Subject: CU-24-00006 Silver Ridge Ranch
I-90 Exit 70 Lt., Easton State Airport vicinity

Case Number CU-24-00006

TO: All Staff
FROM: Public Works Plan Review Team
DATE: August 7, 2024
SUBJECT: CU-24-00006 Silver Ridge Ranch

SUBJECT: WDFW COMMENTS ON CU-24-00006 Silver Ridge Ranch

SHEET:
SP-5

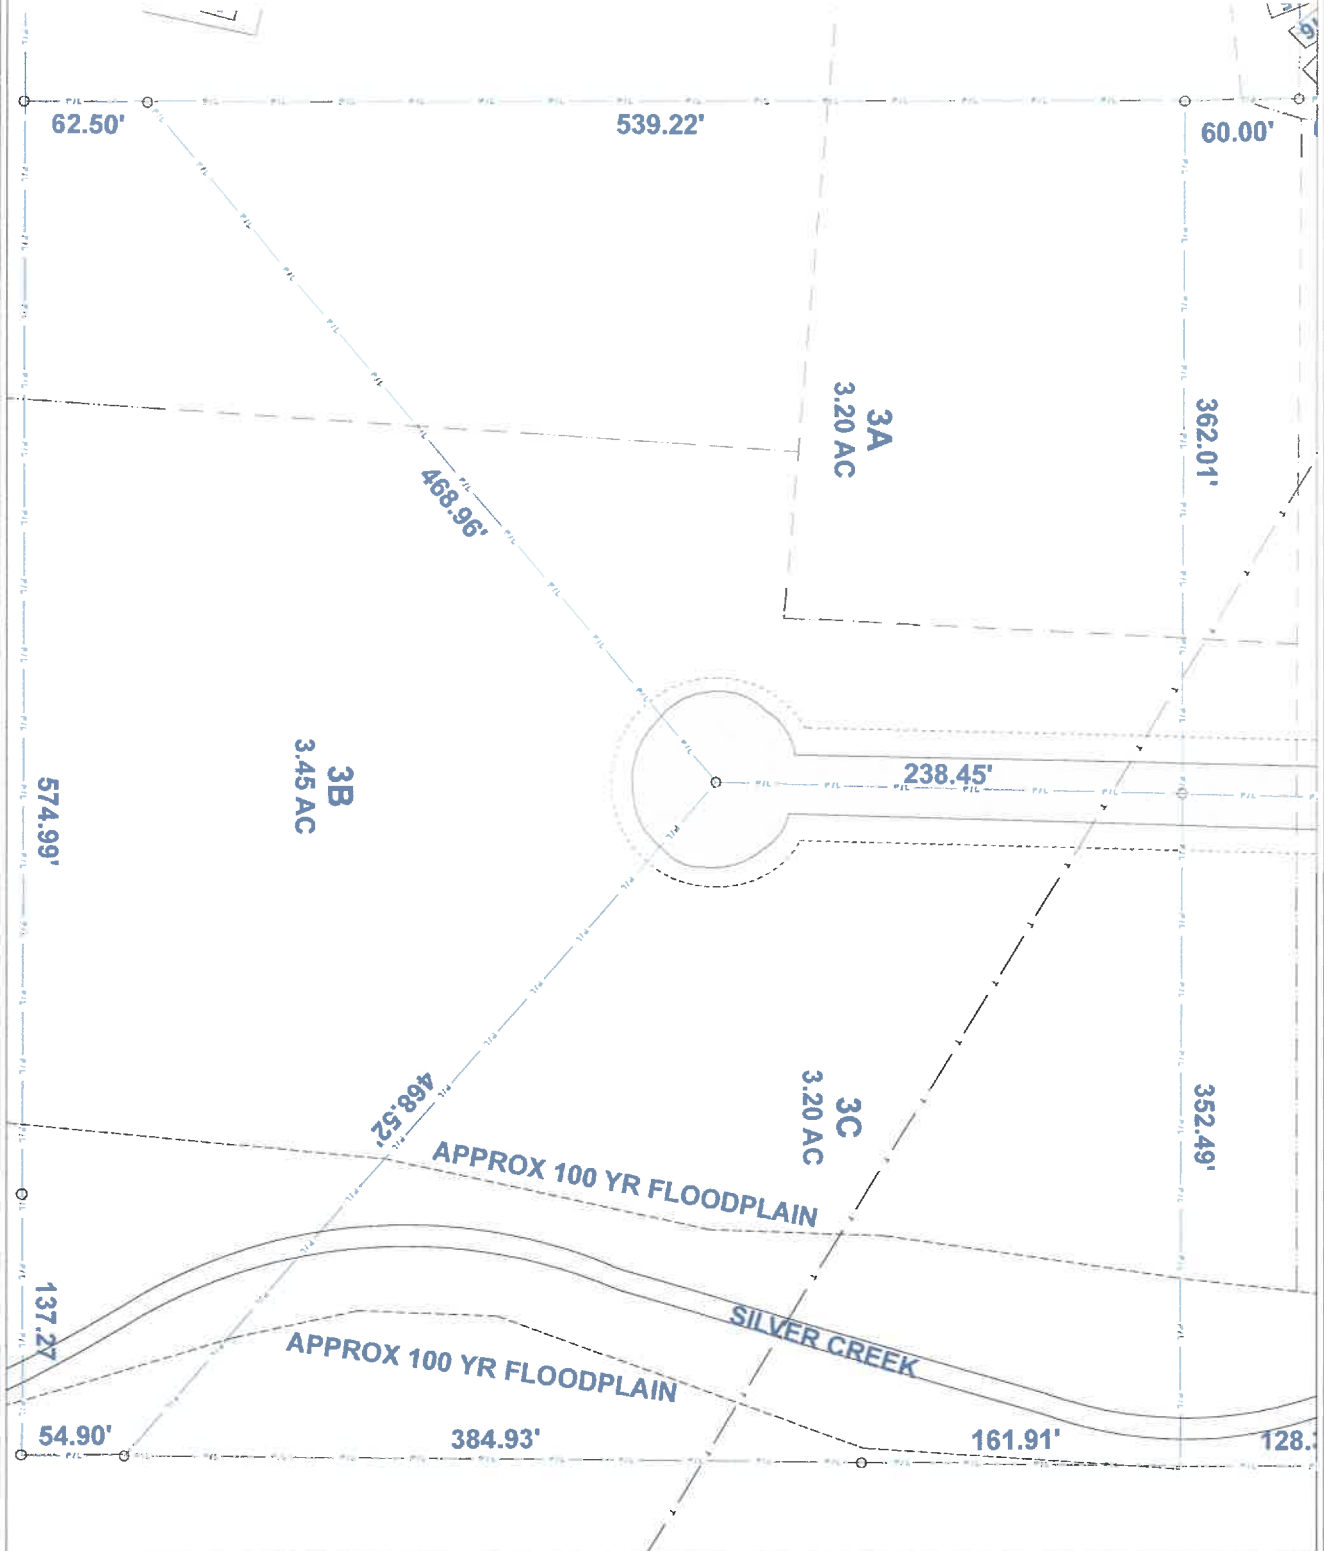
The site plans on file show existing access roads that are not evident on recent aerial photography. For example, the site plans show an existing cul-de-sac style access road on the 7 eastern parcels, which is not apparent on aerial photography.
